Application No: BR/232/24/HH
Site Address: 11 Chichester Road Bognor Regis PO21 2XG
Description of works: Proposed loft conversion. Adjustments to the fenestration.

OWQC73098

PROPOSED SECOND FLOOR PLAN  
SC. 1:100 @ A3

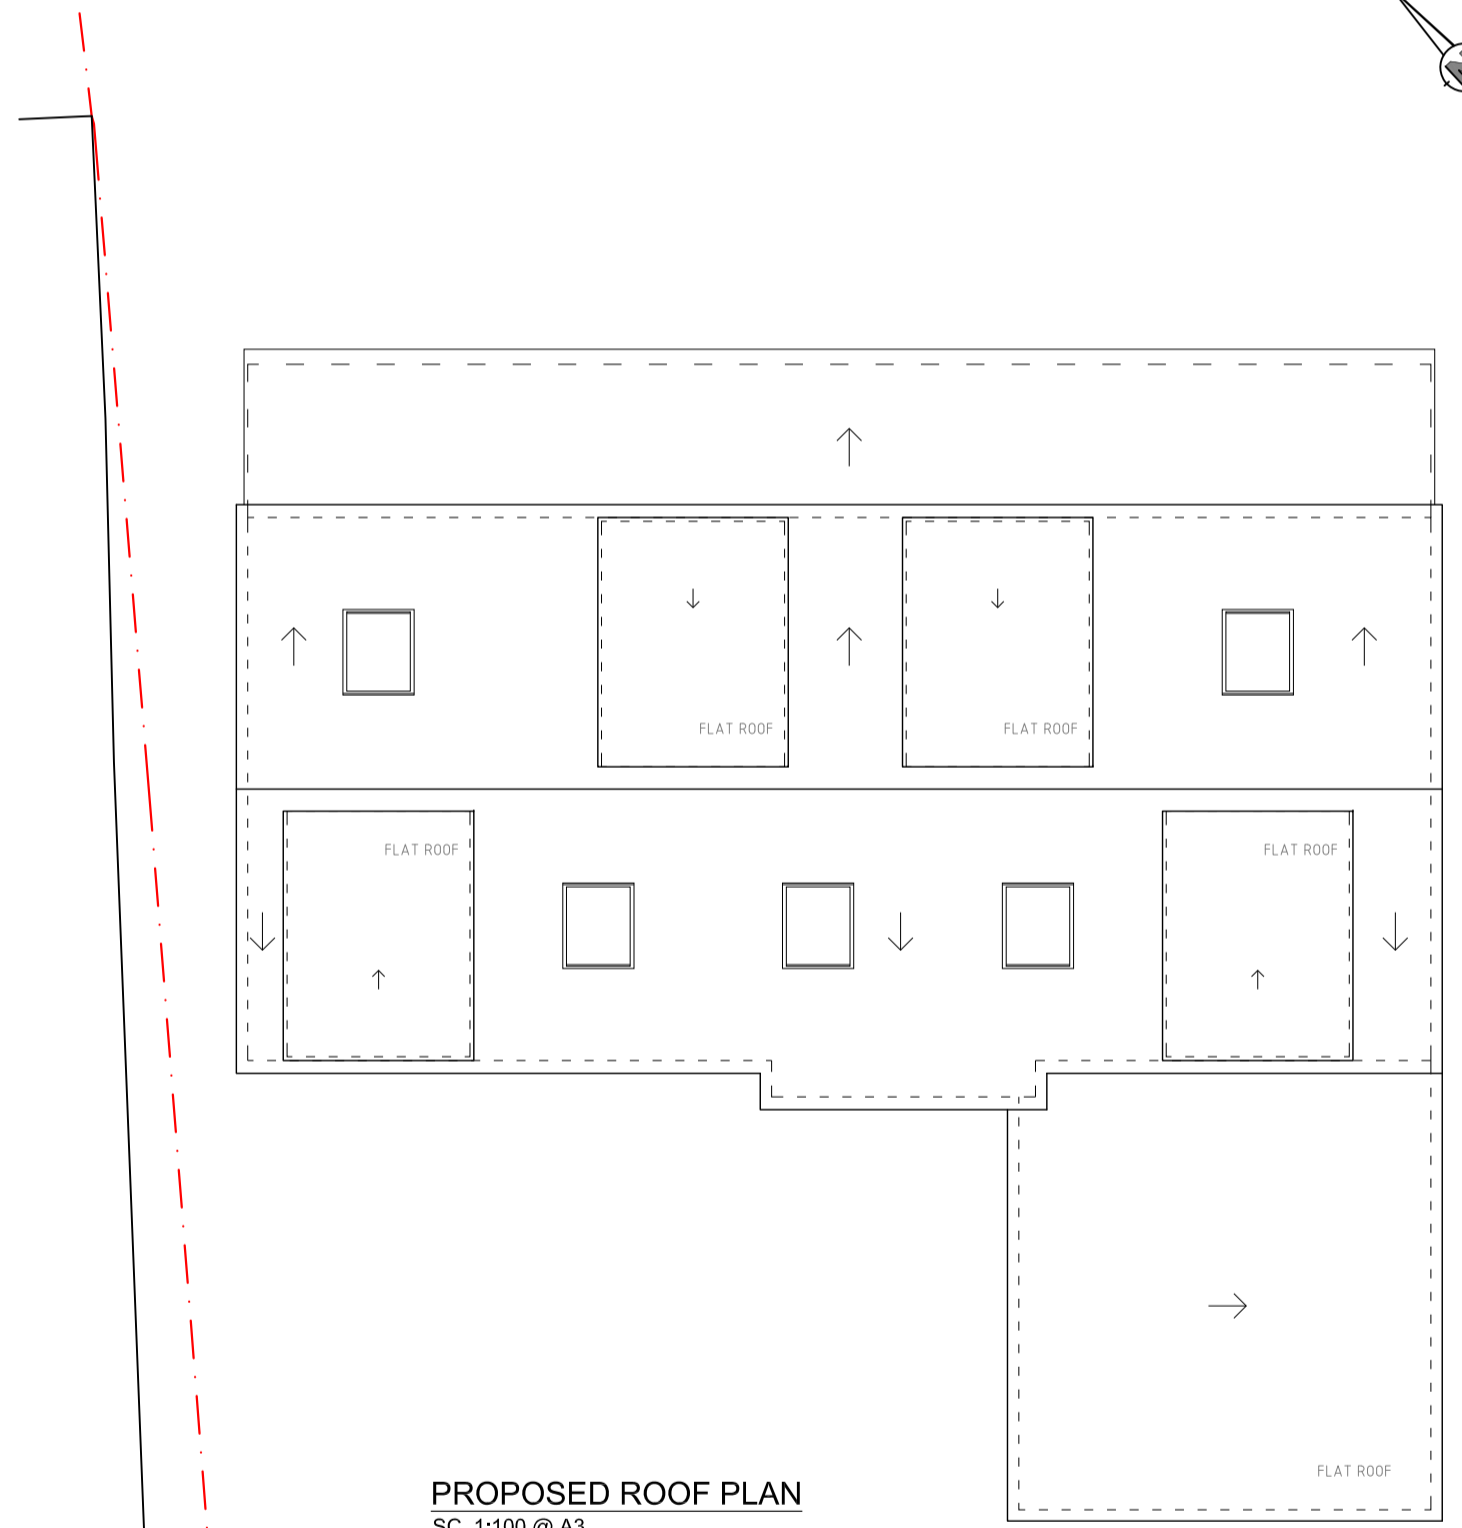
OBJECTION The scale and height of the building, with the addition of dormers to the rear, are such that it has unneighbourly and significantly adverse impacts on the amenities of the occupiers of the neighbouring property to the east (81 Annandale Avenue) by way of appearing overbearing and oppressive in contradiction with Policies D DM1 and QE SP1 of the Arun Local Plan.
